Re: HR Green Development/4 Site Investments – Sketch Plan

This firm represents the Upper Black Squirrel Creek Ground Water Management District (“the UBS District”), a ground water management district formed and operating under the Colorado Ground Water Management Act, C.R.S. § 37-90-101 *et seq.* Applicant, HR Green Development LLC, on behalf of 4 Site Investments, LLC, provided materials in support of its application for a Preliminary Sketch Plan for its proposed Grandview Reserve subdivision development. Grandview Reserve is located within the UBS District and, as explained in the Applicant’s application, will consist of 3,261 residential units on 768.2 acres bounded by the north by 4 Way Ranch, the south by Waterbury, the east by Highway 24, and the west by Eastonville Road. The UBS District reviewed the Applicant’s application materials and submits the following comments:

According to Applicant’s April 2020 Water Resources and Wastewater Report (“Report”) included in Applicant’s application, Grandview Reserve will require 1059 acre-feet per year, or

GRANDVIEW RESERVE SKETCH PLAN
 SKETCH PLAN

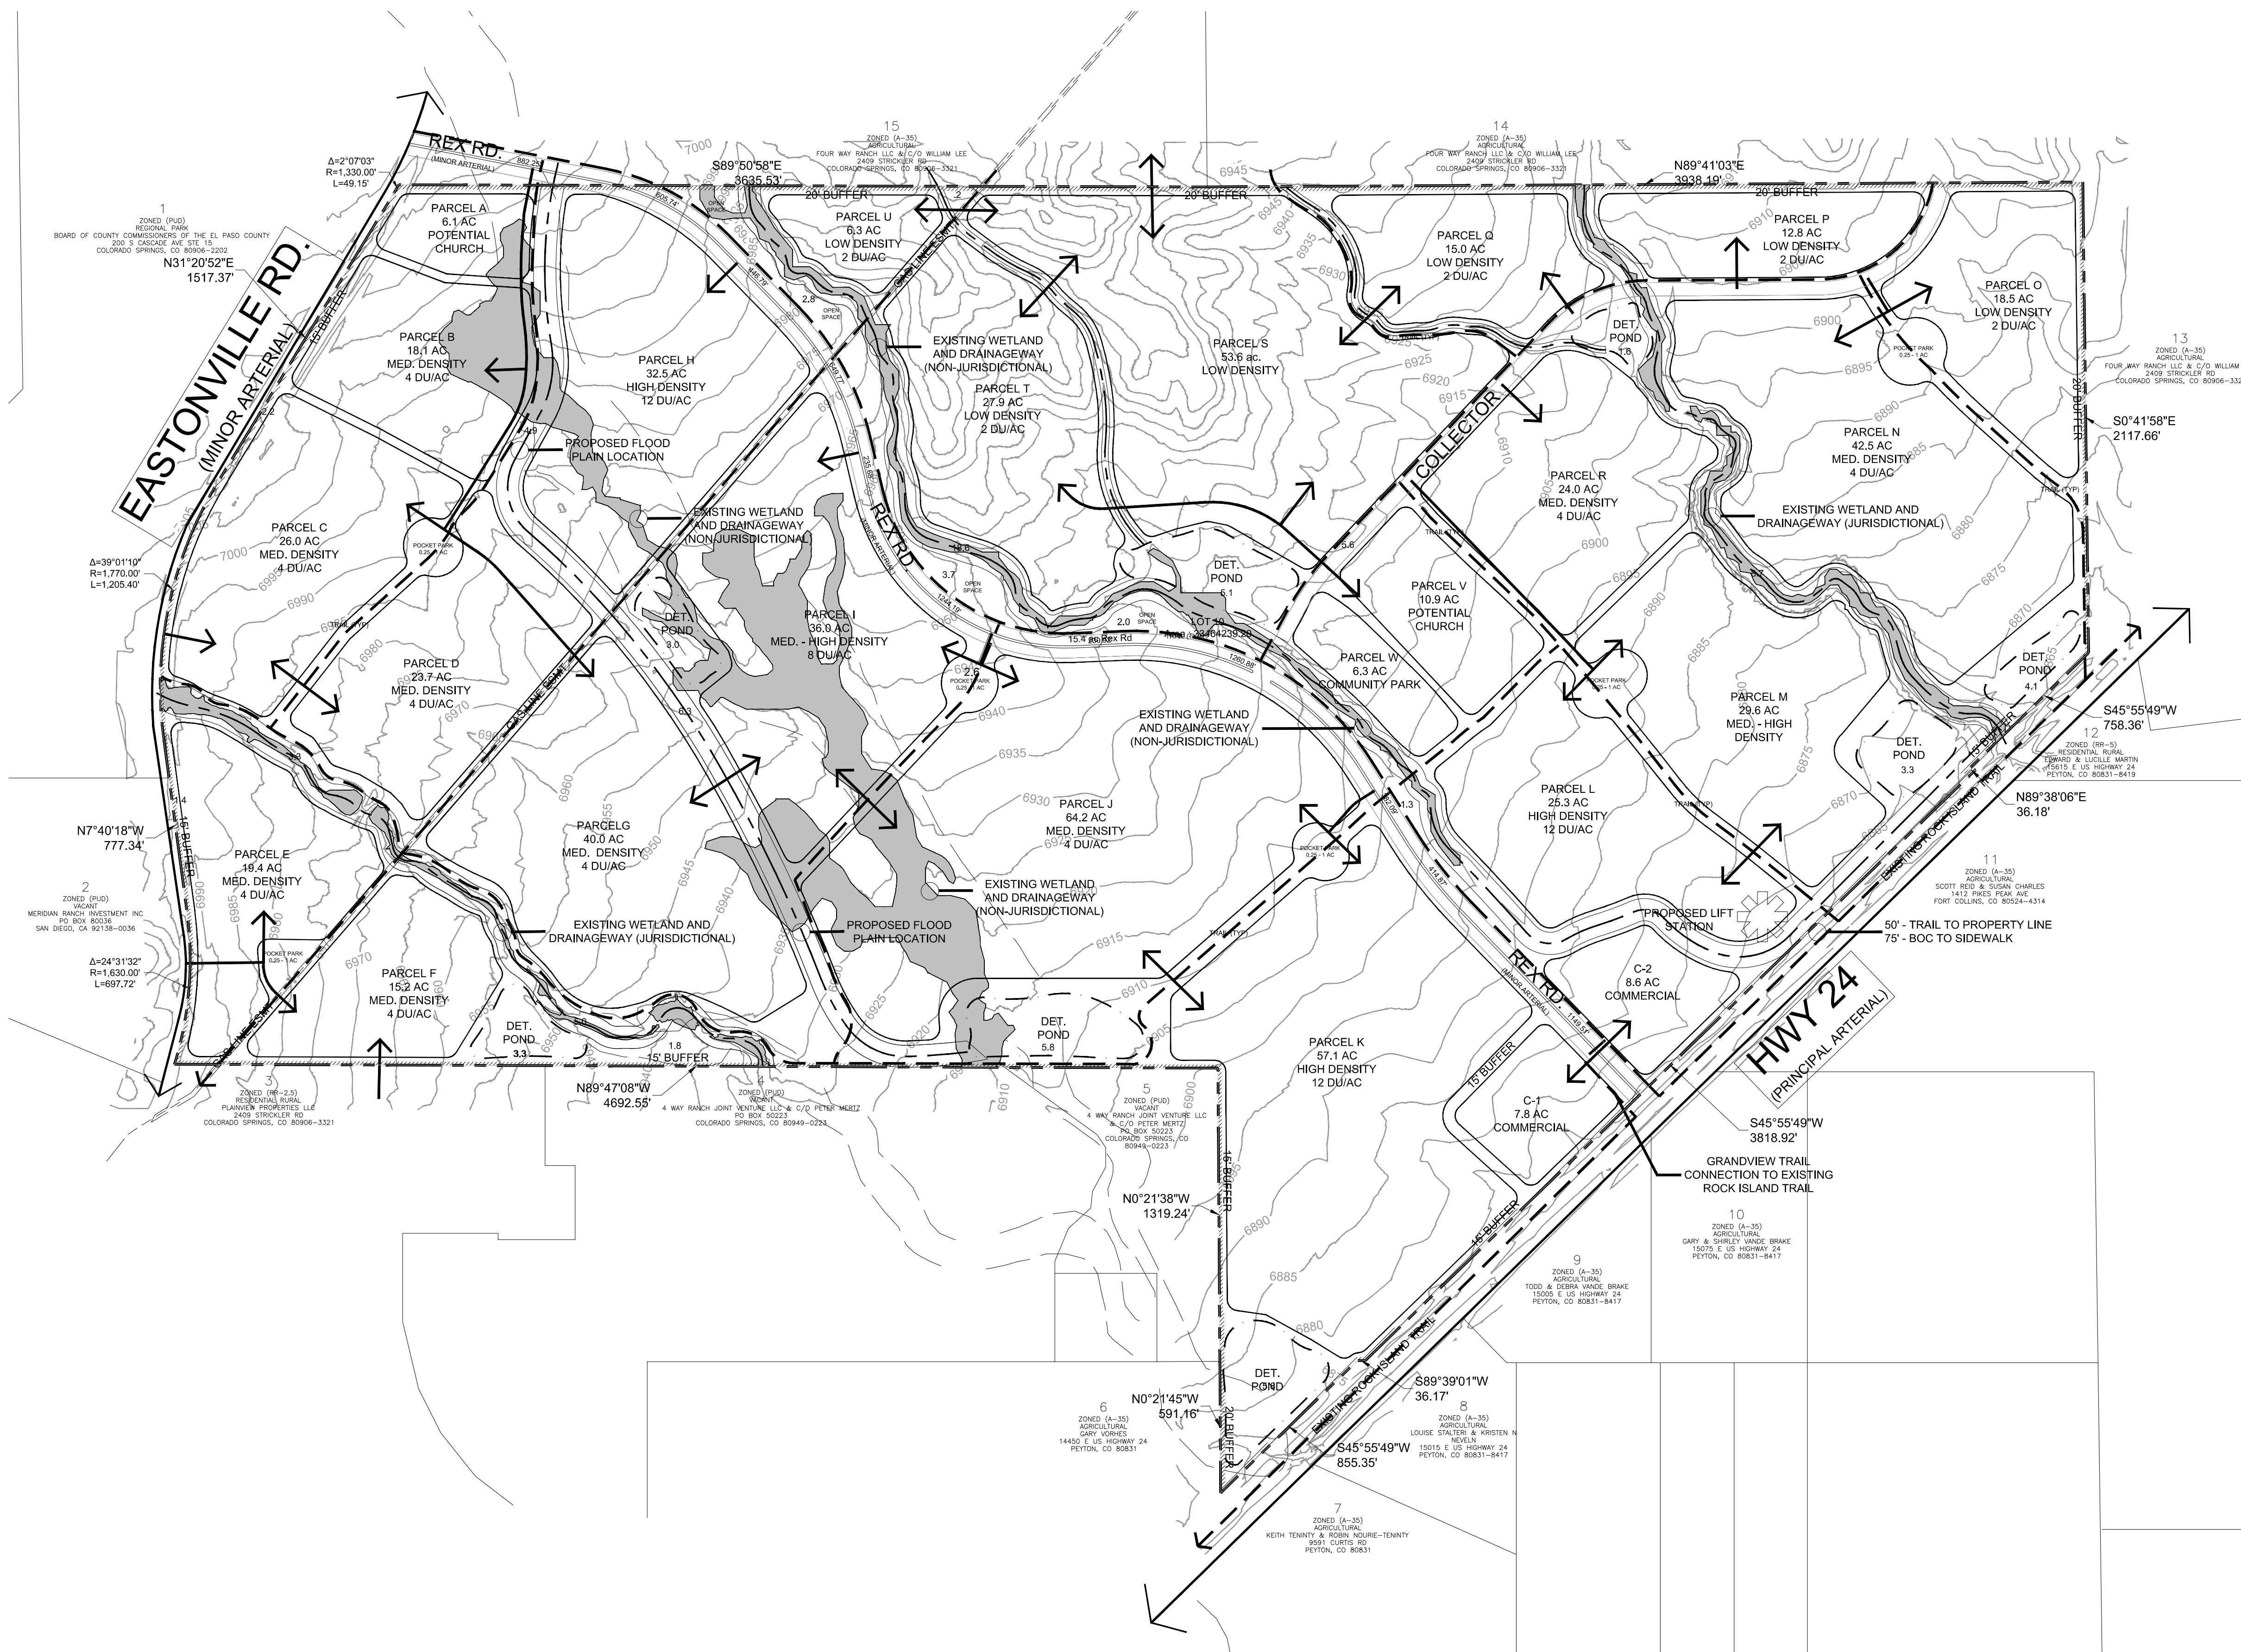
Applicant does not provide adequate information on how surface run-on and run-off will be managed for Grandview Reserve. The materials provided indicate four natural drainage channels traverse the property from the Northwest to Southeast and that these drainages will be incorporated into drainage control. However, there is insufficient information regarding annual run-on and run-off volumes and what treatment might be necessary prior to exiting the 768 acre property.
